Recommendation Report for Planning Permission

REF NO: AL/100/18/PL

LOCATION: Nyton House
Nyton Road
Westergate
PO20 3UL

PROPOSAL: Internal alterations together with replacement of 3 No. existing PVCu windows with sliding sash windows & reinstatement of bricked up windows on first floor.

Proposed West Elevation

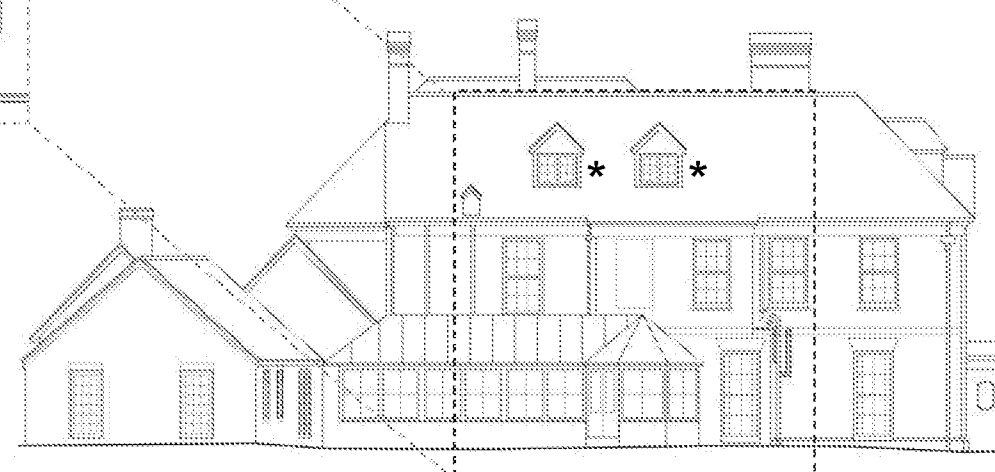
The reinstatement of a bricked up window on the first floor is supported as it would allow the western elevation to be returned to a more sympathetic appearance. Further it would allow the internal arrangement of the room affected by the works to be better appreciated.

FIRST FLOOR PROPOSED PLAN

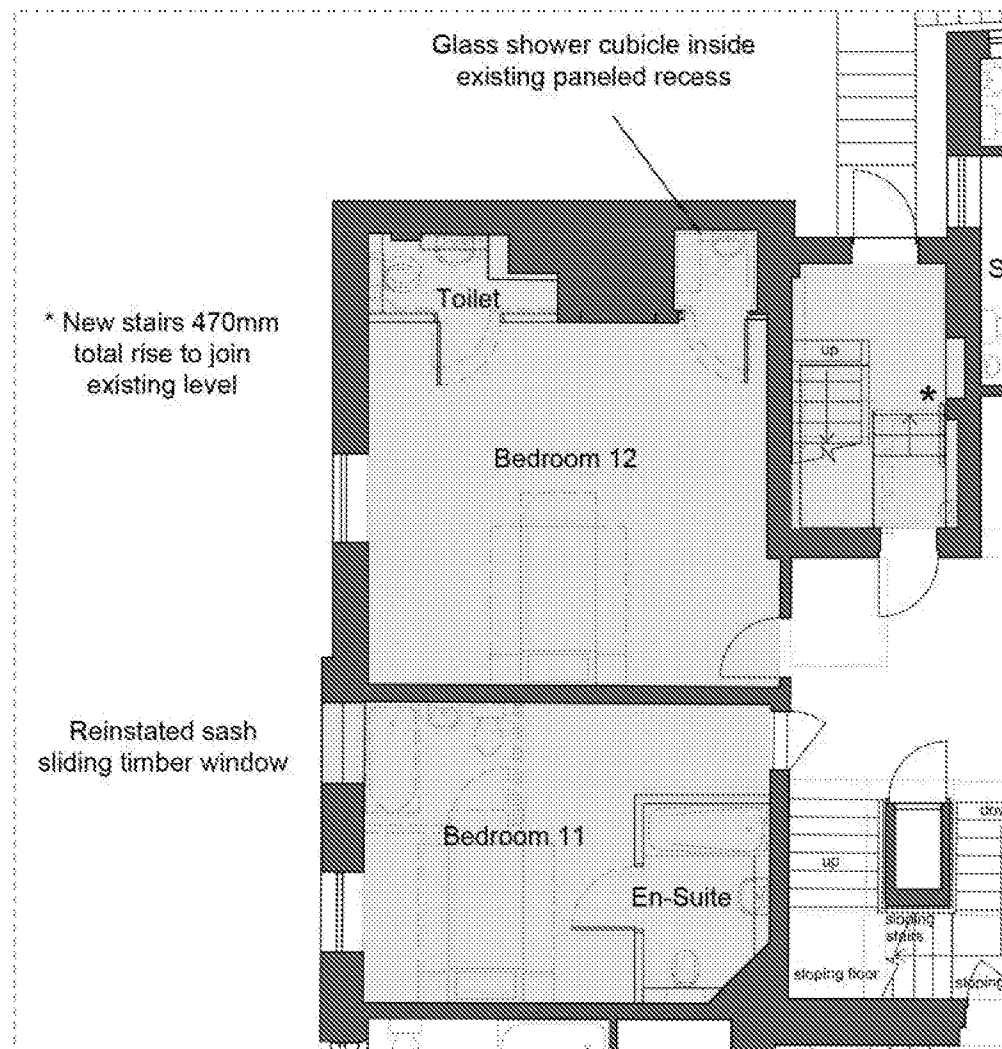
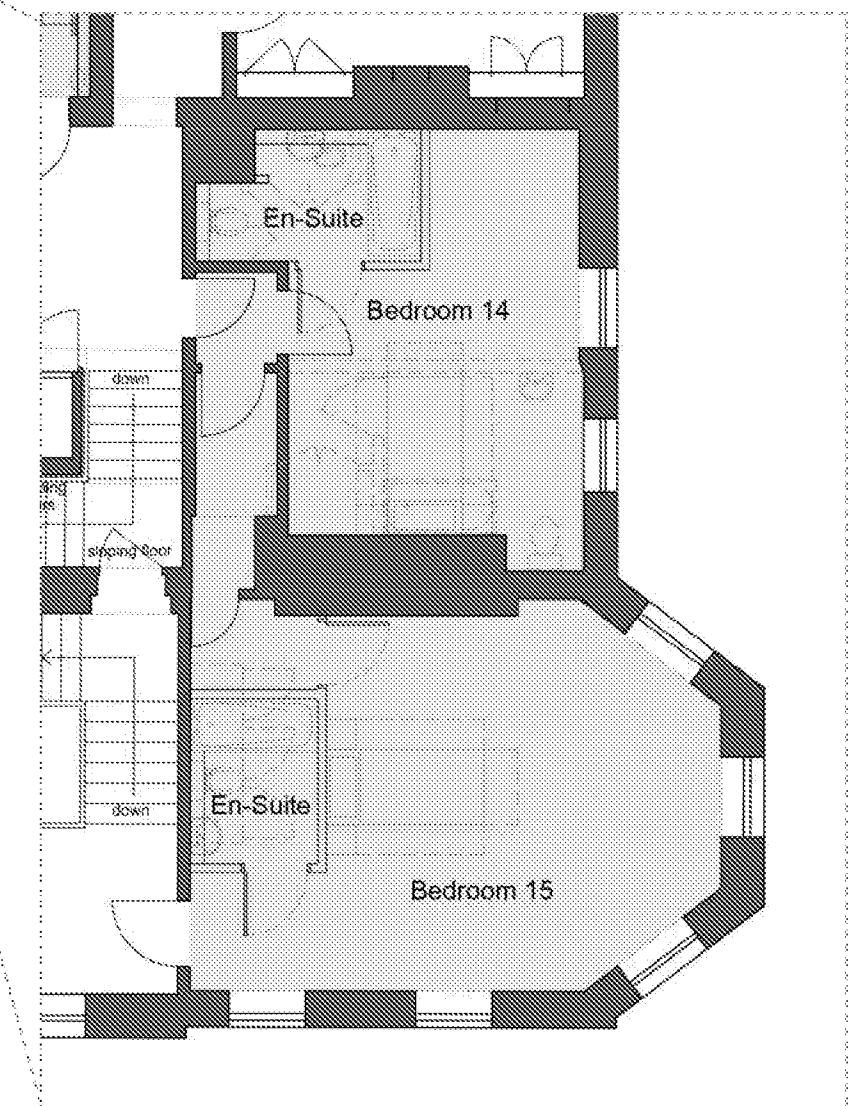
The internal alterations allow for the provision of en-suite facilities in a number of bedrooms. Such alterations are acceptable as they have been positioned so as to minimise the impact upon the rooms, whilst also being reversible, should needs change in the future.

New walls should allow for reversibility and to this end it is important that existing details such as coving and skirting are not harmed by the installation of new stud walls.
